Application No: LU/247/20/PL

Site Address: 57 River Road Littlehampton BN17 5DD

Description of works: Partial demolition of existing building, retention of boundary wall & street facade, partial demolition of boundary wall to incorporate new pedestrian gateway & gate, erection of 6 No. flats in 2 blocks connected by shared stair & lift core, on site parking yard for 8 No. cars & 8 No. cycles & space for communal refuse & recycling bins. This application affects the character & appearance of the Littlehampton River Road Conservation Area & is in CIL Zone 4 (Zero Rated) as flats.

Thank you for your internet representation made on 12th October 2020 which has been recorded as no objection with the comments as follows:

1908-P-160-I PLAN OF STRUCTURES TO BE REMOVED

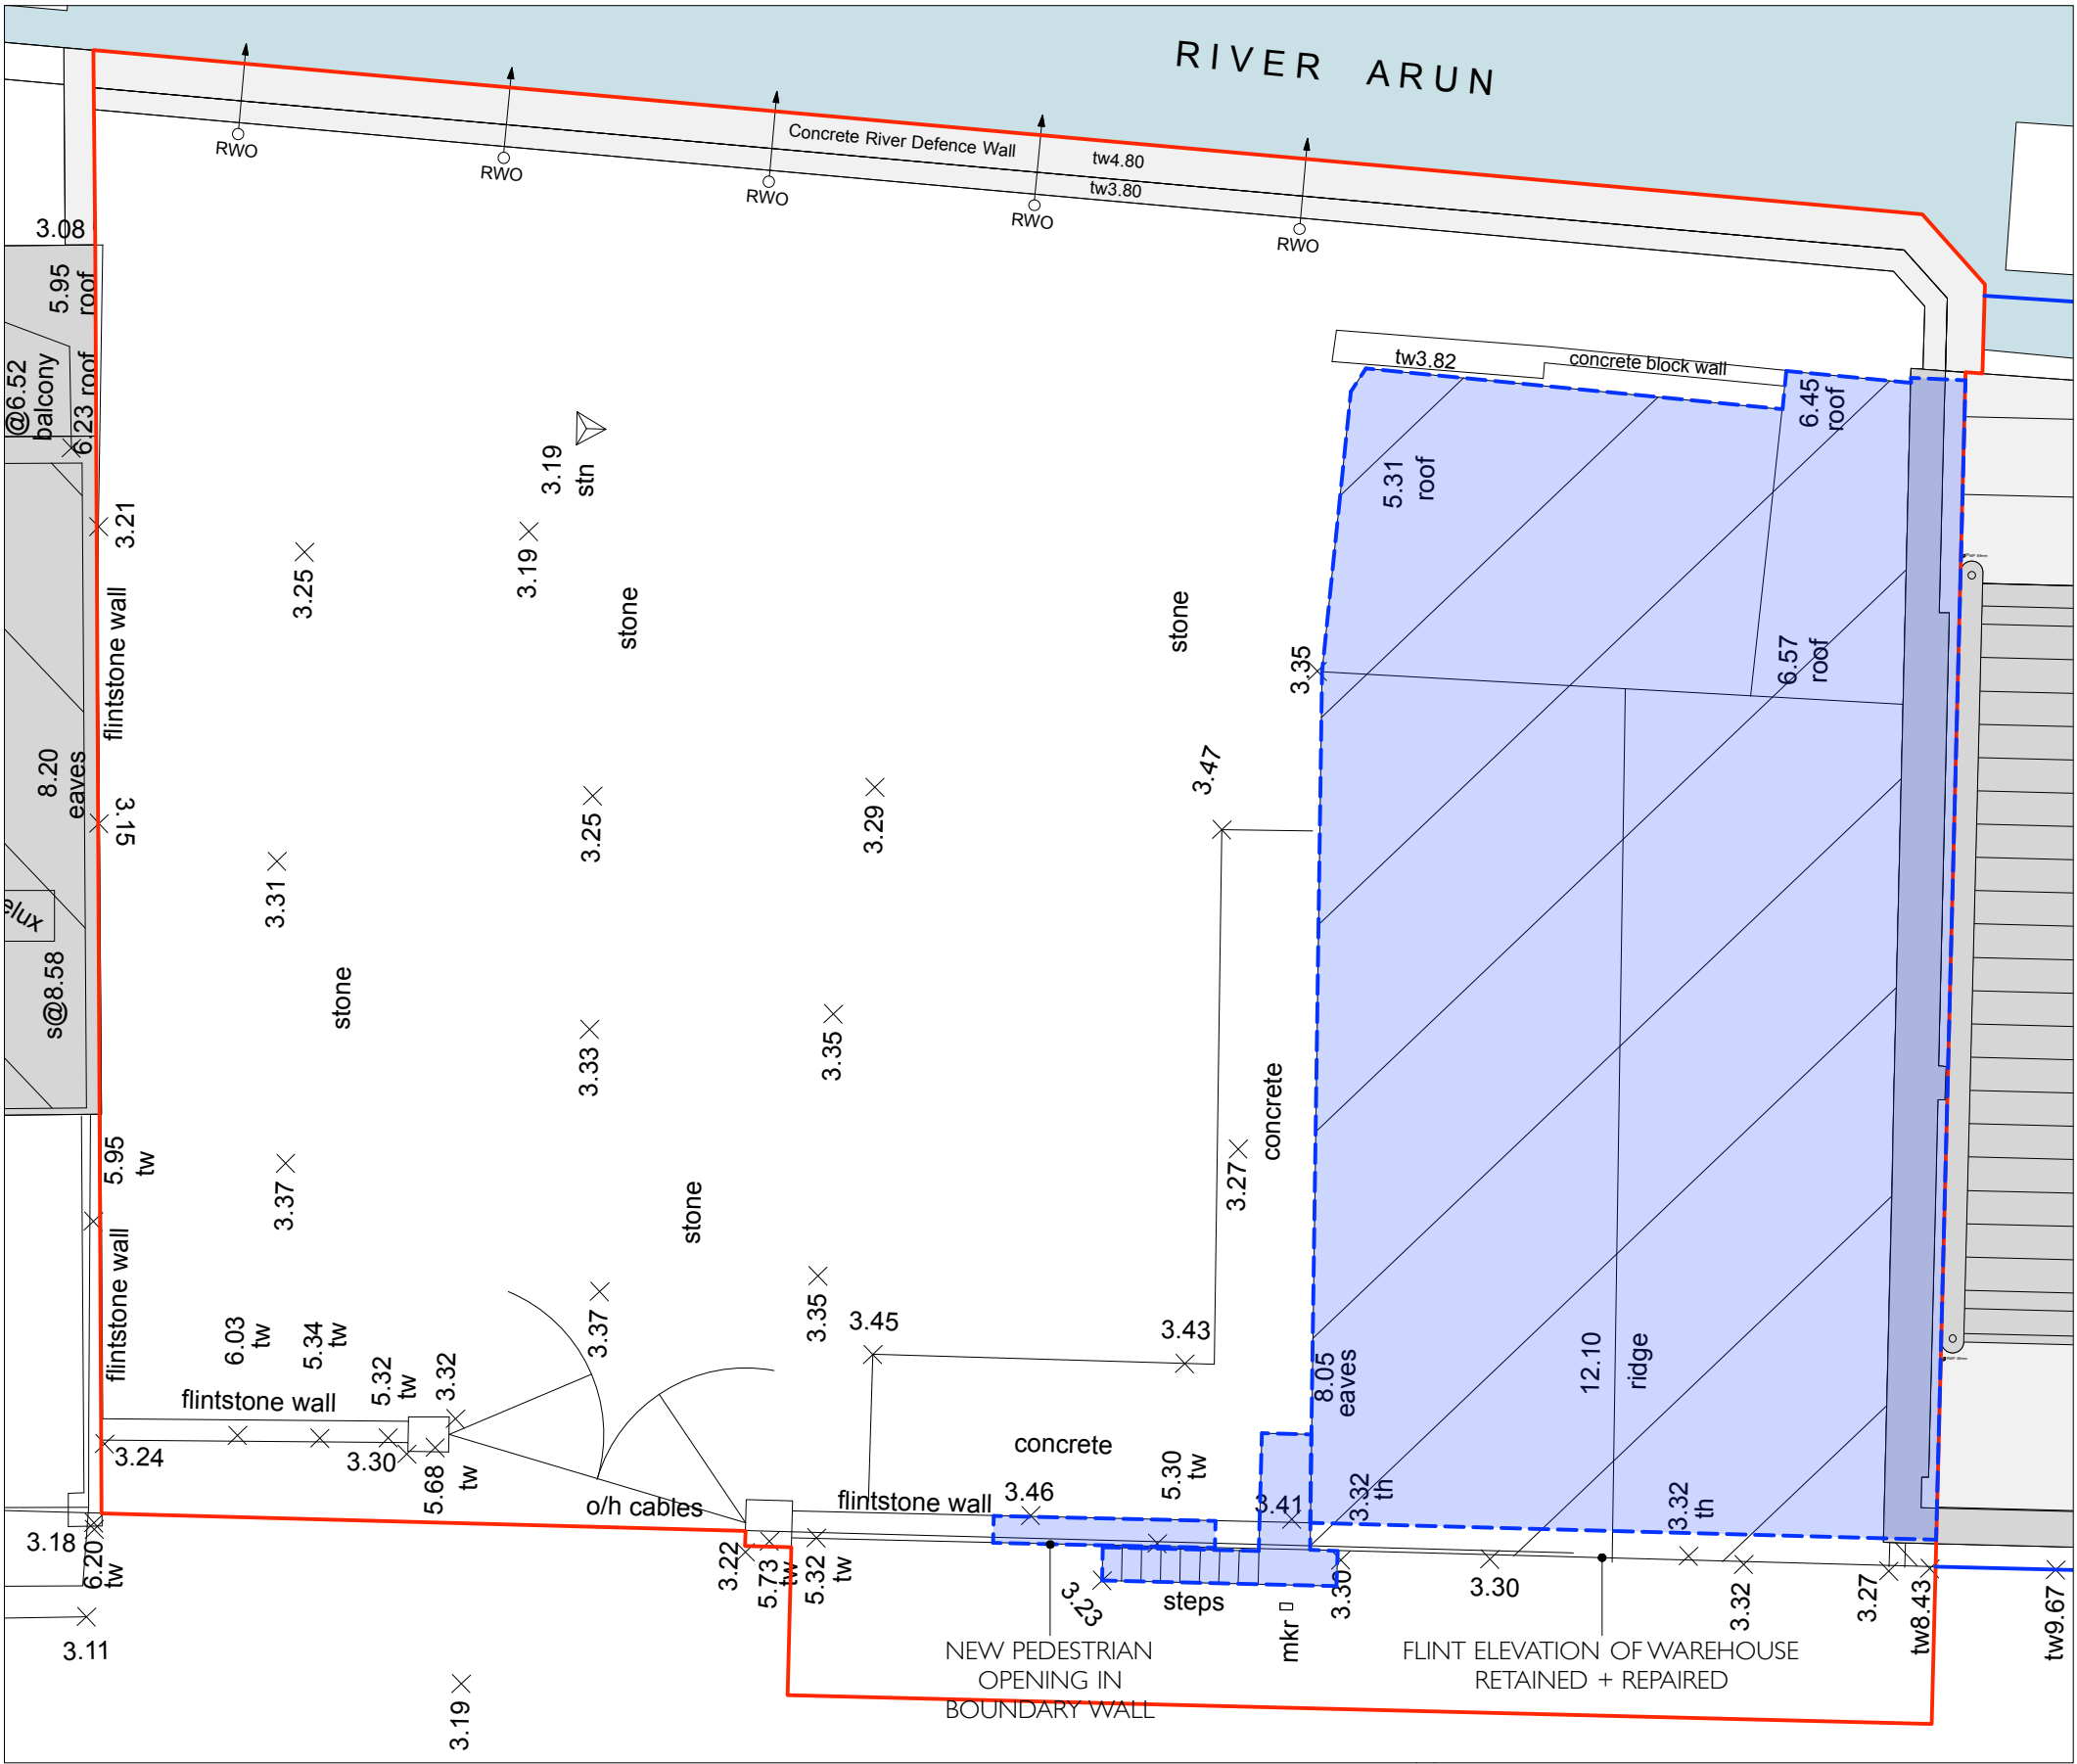
(2) Given the high local heritage value of the building and its need to be considered as a non-designated heritage asset, every attempt should be made to retain it without substantial removal of historic fabric. The condition report submitted with the application does not indicate that the building is in poor structural or dangerous condition and the issue surrounds the viability of finding uses for the building given the costs of repair. In coming to a possible view that the substantial demolition of the building should be permitted, the Council needs to be fully satisfied that there is no viable appropriate use for the building including residential conversion, and that there is no possibility of an historic building preservation trust taking on the repair works and finding an appropriate use.

(c) the submission of a method statement indicating how the retained front elevation will be protected during construction works and how its long term stability will be ensured.

TITLE: PROPOSED SOUTH EAST ELEVATION

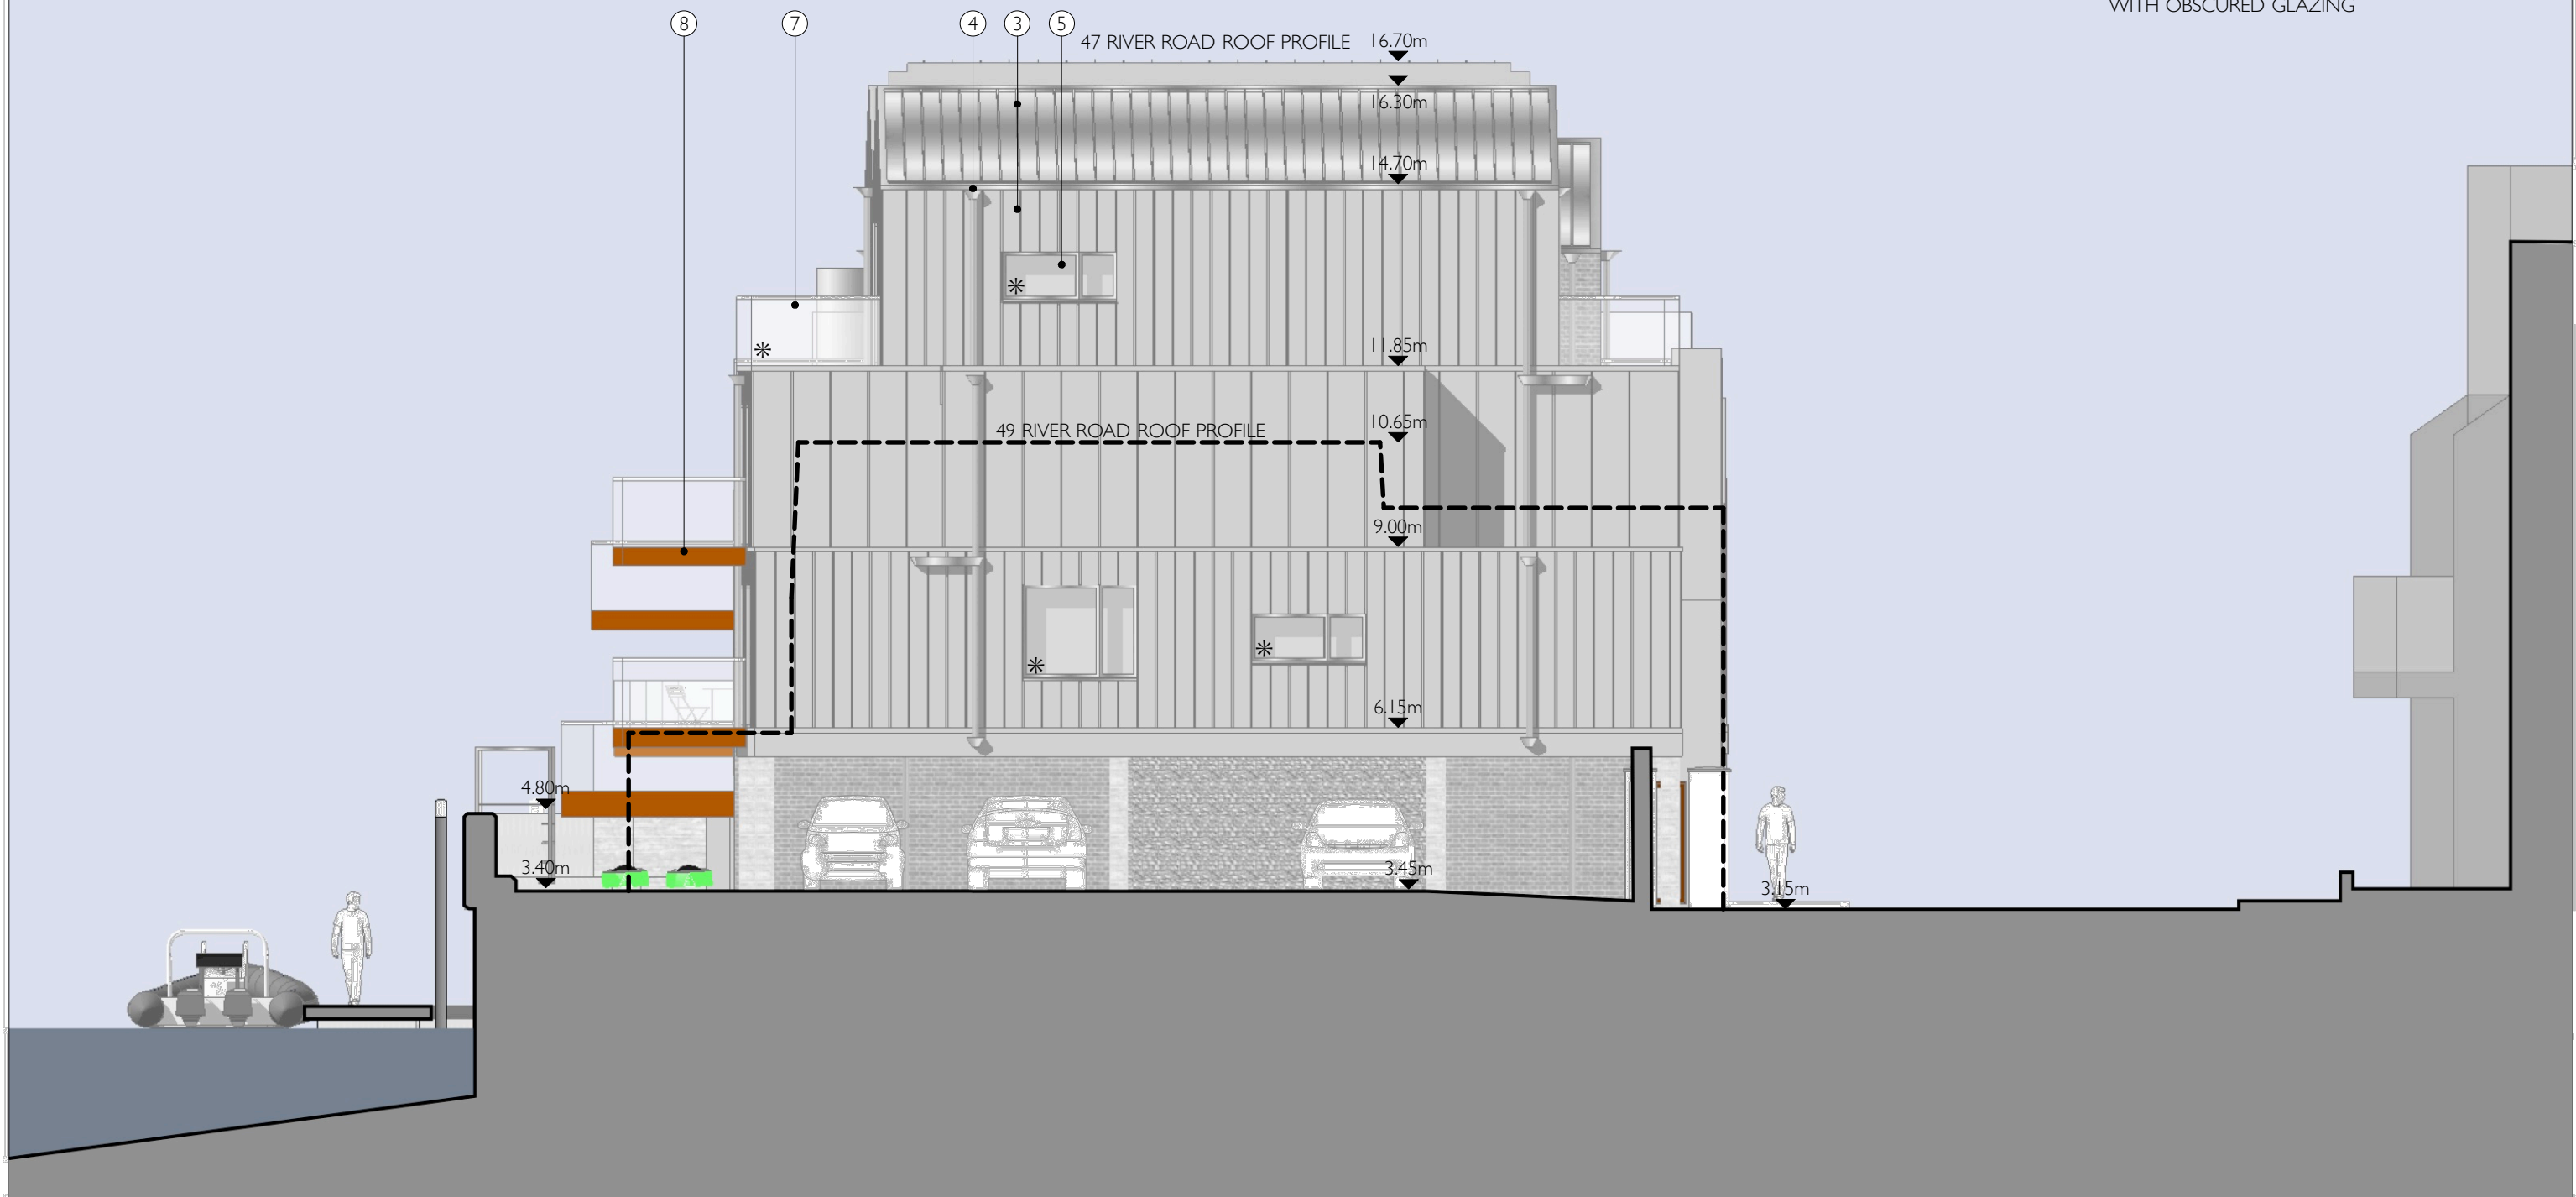
(3) Assuming the Council is minded to grant permission then, If carried out in high quality materials and finishes and detailing, the proposed new buildings should make a positive contribution to the character and appearance of the conservation area. Perhaps more details are needed in respect of the glazed link between the buildings containing the access stairways since as shown currently on the plans it appears rather

discordant in form and massing with those of the other structures.
